From: [Yang, Amber](#)
To: [Jeremiah Cromie](#)
Subject: RE: VA-23-00003 Sparks Park - Re-notice of Application due to SEPA requirement; rw 130305
Date: Friday, May 12, 2023 6:02:11 PM

Subject: VA-23-00003 Sparks Park - Re-notice of Application due to SEPA requirement

PRELIMINARY SITE PLAN
 MOUNTVIEW GROUP LLC TRAVEL CENTER
 WEST SPARKS ROAD
 EASTON, WASHINGTON

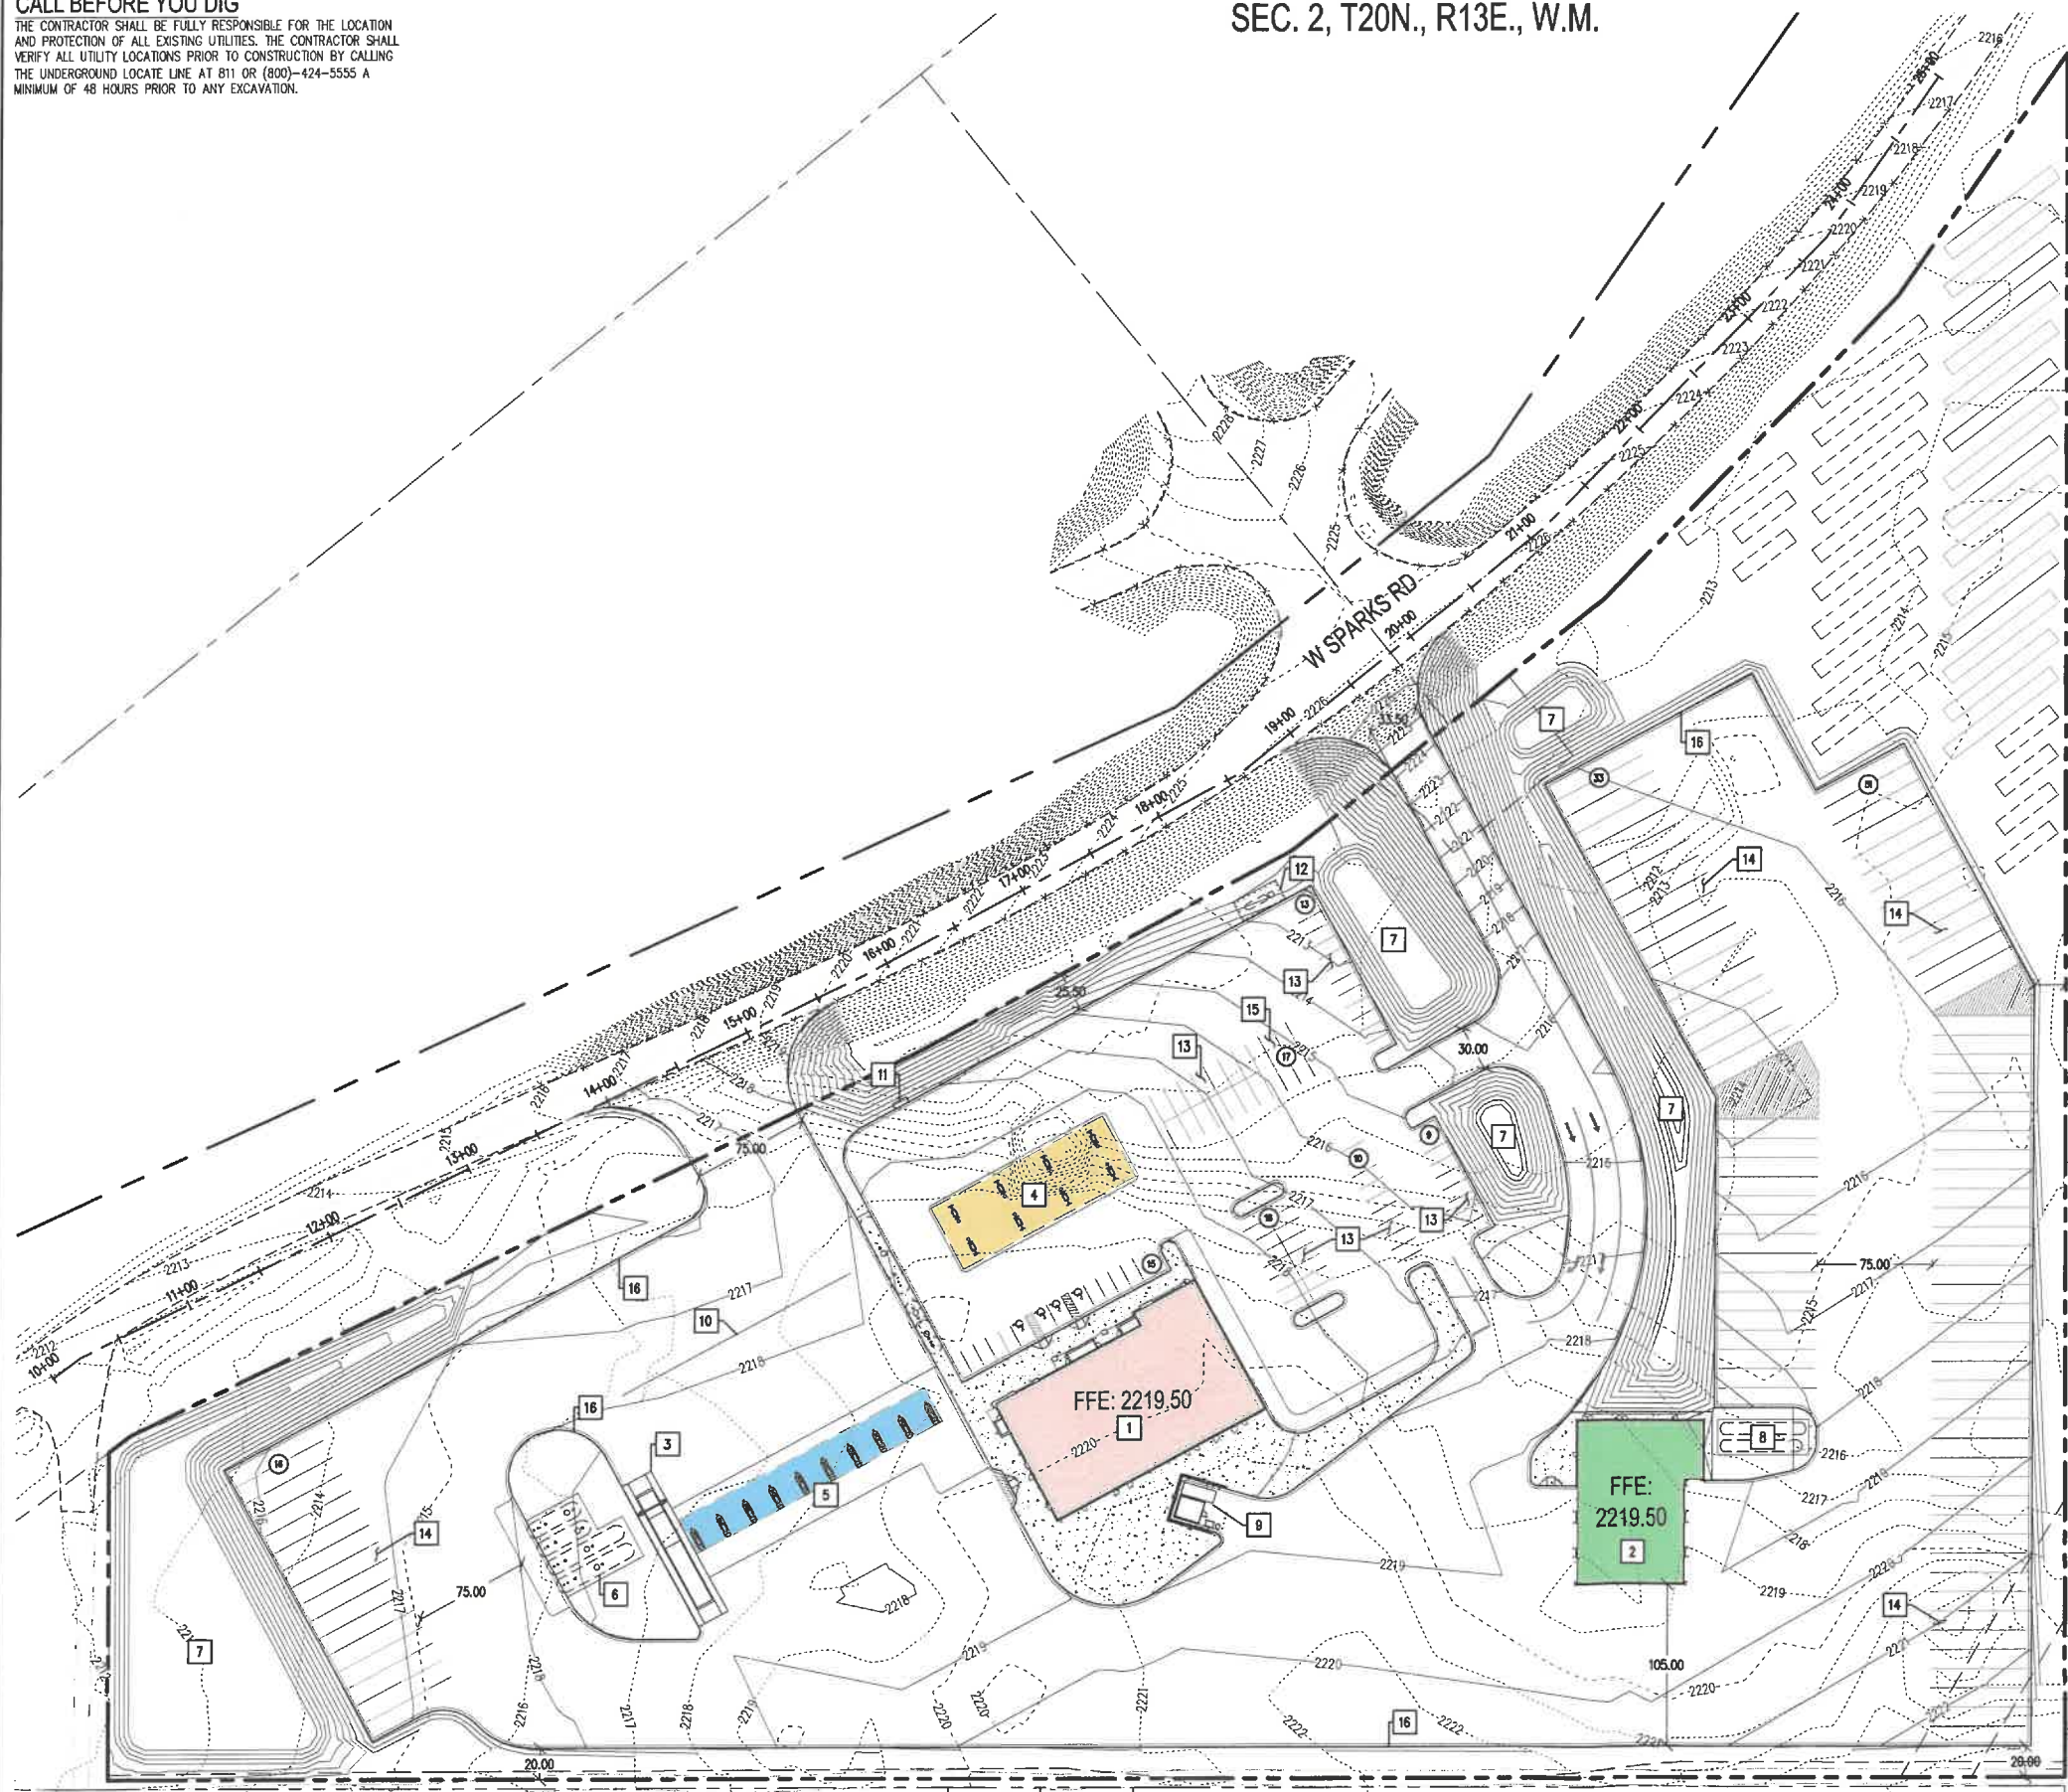
PSE has 3 phase cables and underground vaults along W SPARKS RD and overhead wires and pole along the east side of the parcel.

Would you please ask the customer to do locate on the electric facilities on his parcel so I know if they are in the ROW or other parcels, instead of his? Also, is this customer requesting any change in setback within the 10' frontage along W SPARKS RD? thanks!
